FW: A/30/26/PL Highdown Garden Centre, Littlehampton Road, Angmering - MSC2116

Subject: A/30/26/PL Highdown Garden Centre, Littlehampton Road, Angmering - MSC2116

Further to receipt of Southern Water's letter dated 16th March 2026 Ref DSA000052125, we comment as follows:

Drawing No: A9803 - 140 P2

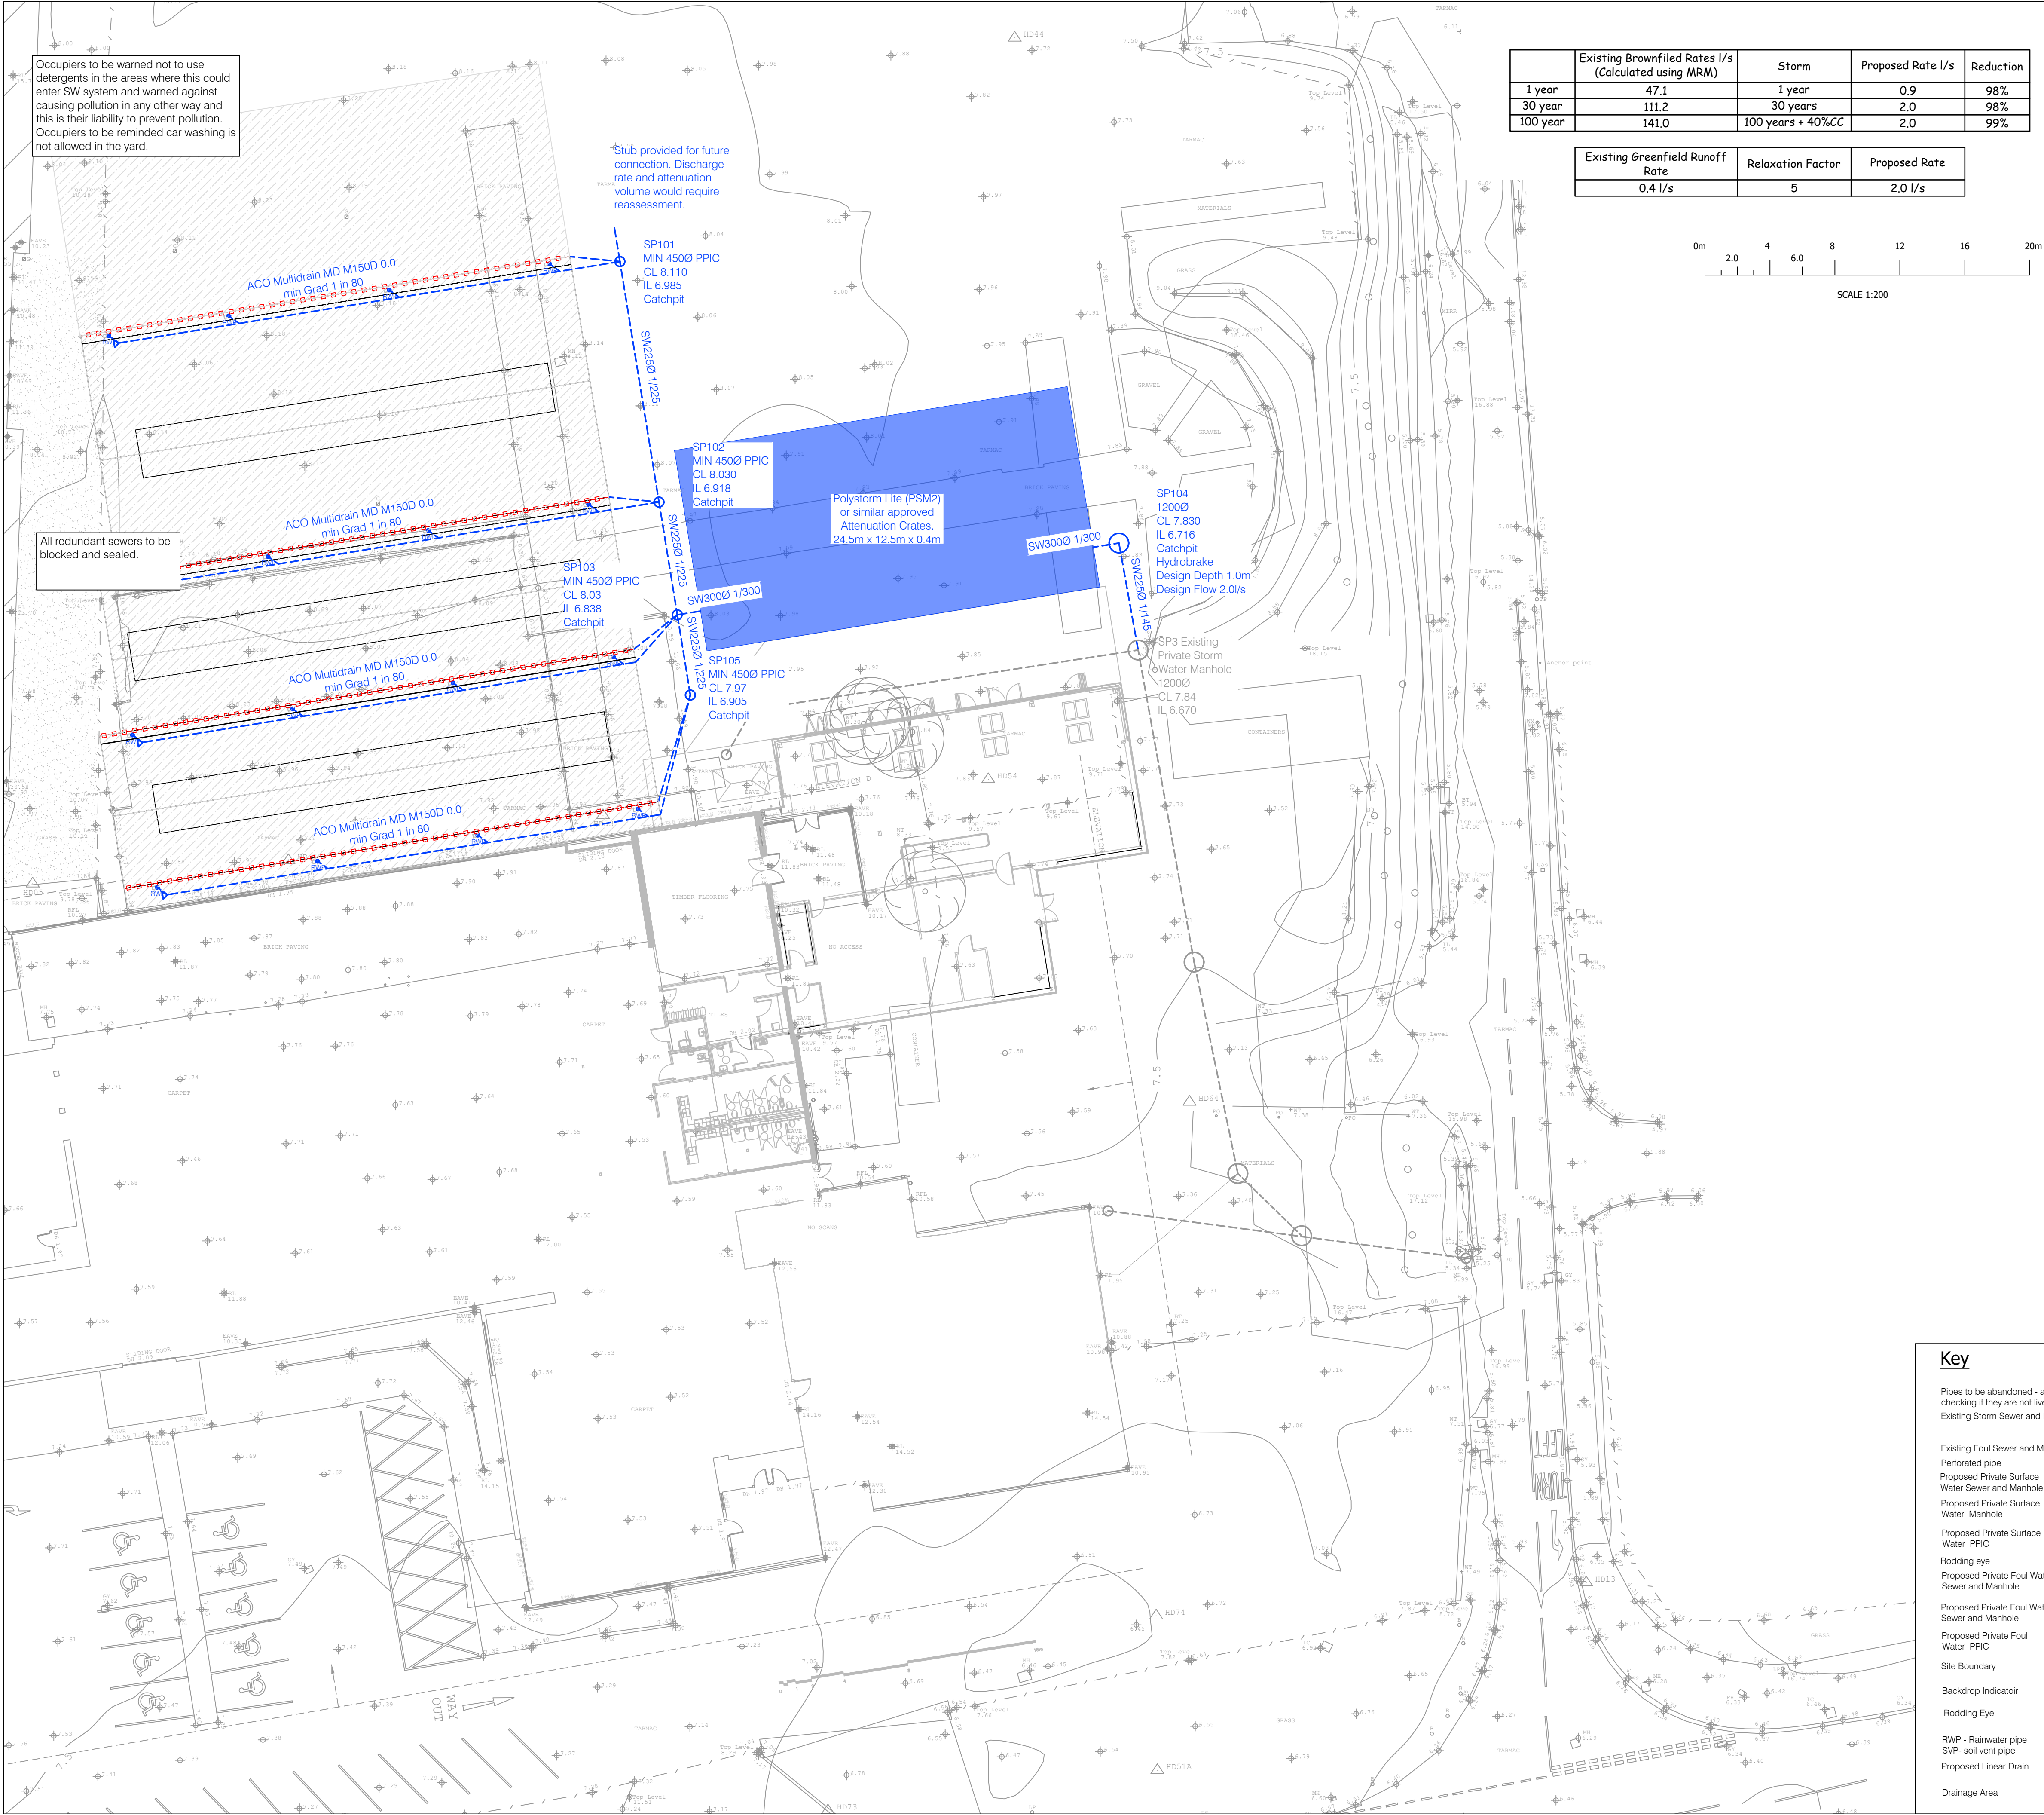
- **Existing drainage system:** Could you provide details of the existing drainage system and the location of the final discharge point? Our engineers will need to ensure it has sufficient capacity.

- **Infiltration:** Why has infiltration been discounted? Could you confirm (and submit the evidence) that groundwater monitoring and infiltration testing have ruled out the use of infiltration? We would expect the SuDS hierarchy, as set out in the National Standards for SuDS, to be strictly followed.

- The application is in respect to the design and construction of new outside sales canopies and hence the only additional drainage provision is for surface water drainage as detailed on drawing 140, there is no alteration or additions to the foul drainage requirement whatsoever.

- Our drawing has also included for the provision of the necessary attenuation crates as designed by our Chartered Engineer before connection to the existing private surface water on site.

- There are no proposed soakaways, we have rainwater pipes and drainage channels connection to the existing private water drainage via designed attenuation.

Drawing 140 already shows the existing surface water drainage run marked in grey (as existing). It runs from SP3 to SP5 (which is already a flow control point) and then through to EX SP2 and the outfall. Have put an abstract below for ease of reference.

As noted in our earlier email the scheme will be an improvement on the current arrangement as the area is currently drained as it is an existing canopy or hard paved sales area and the new scheme will now formally attenuate in a crated system.

We are aware of the SuDS hierarchy but unfortunately the ground conditions are impermeable as we have clay for circa 4.3m depth underlain with weak chalk beneath which would not be ideal either.

The site is already formally drained which also substantiates the drainage protocol.
